# Rezoning Transportation Analysis

Petition Number: 2022-193

**From:** Jake Carpenter, PE  
Jacob.carpenter@charlottenc.gov  
980-221-5675

Date	Description
3-22-23	First Review (TM)
04-20-23	Second Review (TM)

SHEET NUMBER  
**RZ-01**

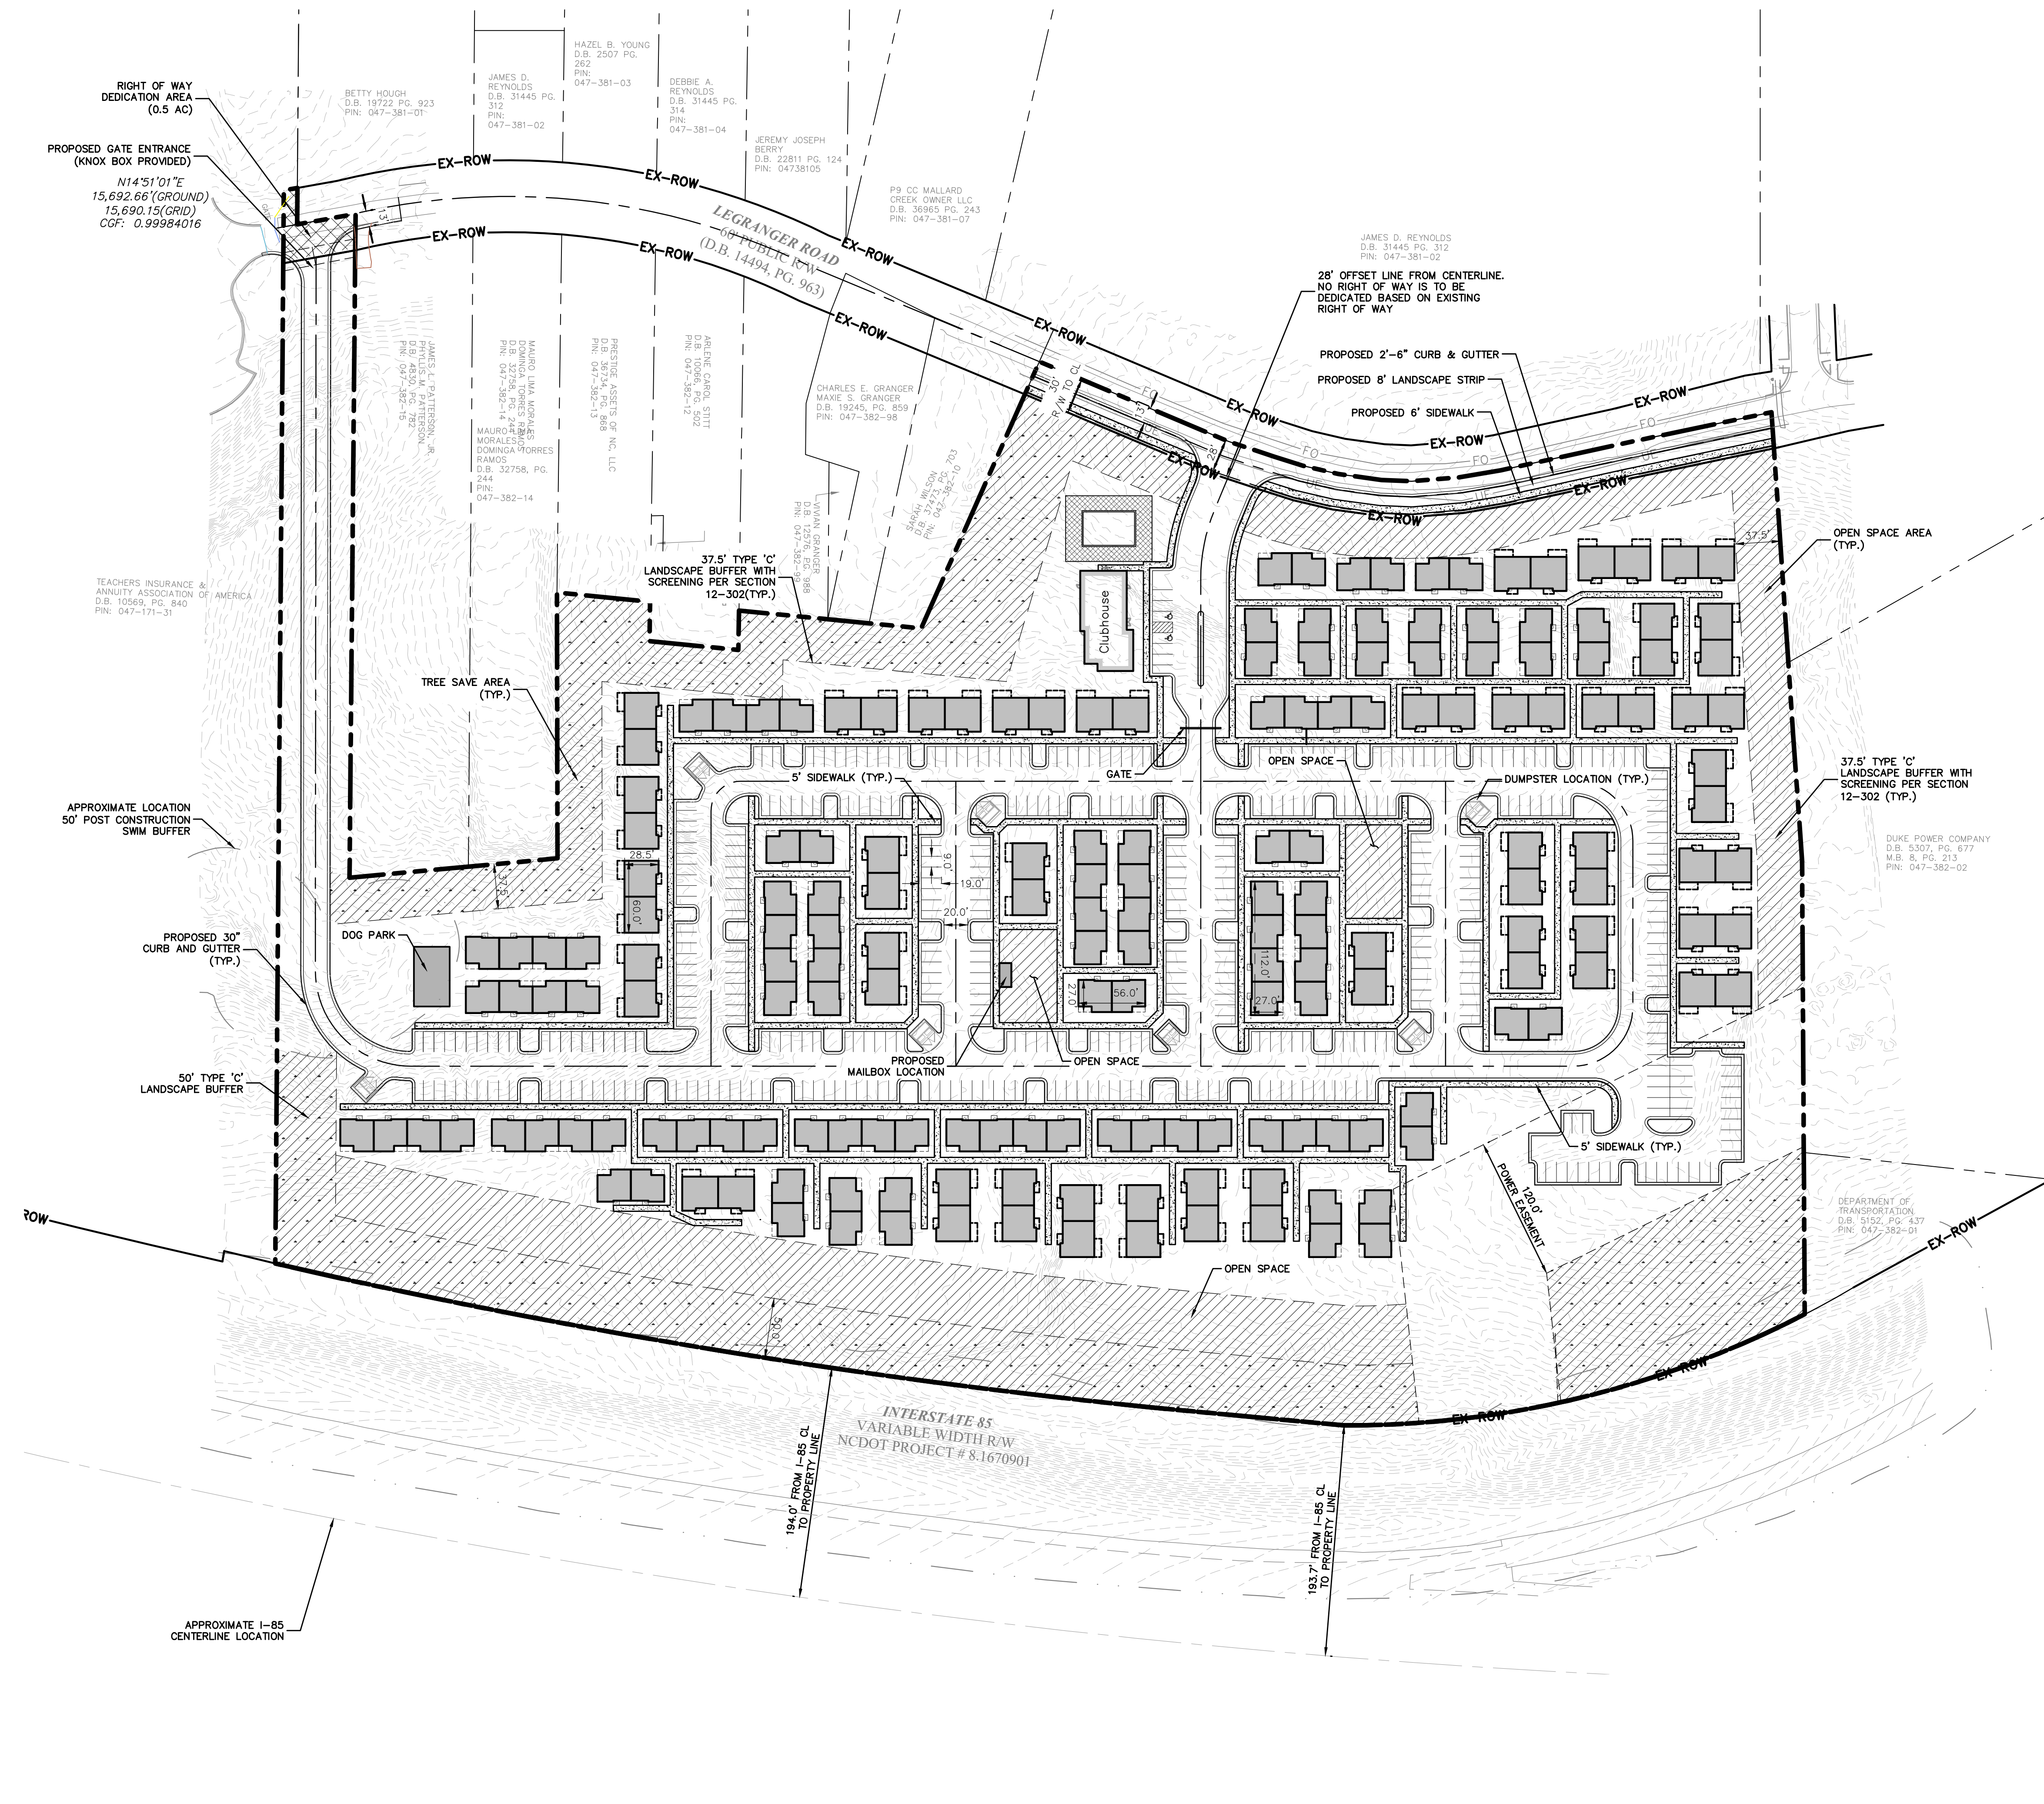
- a. ~~**Legranger Road:** Location of curb and gutter to be 13 feet from roadway centerline to accommodate a roadway typical section matching Charlotte Land Development Standards Manual (CLDSM) U-02.~~

~~Label and dimension the curb and gutter from the centerline for each road on the site plan.~~

- 4. ~~Revise site plan and conditional note(s) to commit to construct an 8-foot planting strip, and 6-foot sidewalk on Legranger Road per Chapter 19. The site plan shall label and dimension both items from the back of curb and gutter or edge of pavement.~~

5. ~~Revise site plan and conditional note(s) to commit to reconstructing Legranger to meet CLDSM U-02 standards along sites frontage including sidewalk, curb and gutter. Roadway improvements shall be coordinated with adjacent development (SDRU-2022-00007).~~

6. ~~**CDOT REQUEST 03-23-23:** CDOT request that Legranger is revised to meet CLDSM U-02 between the sites frontage and the proposed site access to plan west. If this section is not complete the western most site access location shall be required to be restricted to emergency vehicular entrance only. This entrance shall be gated with a knox box.~~
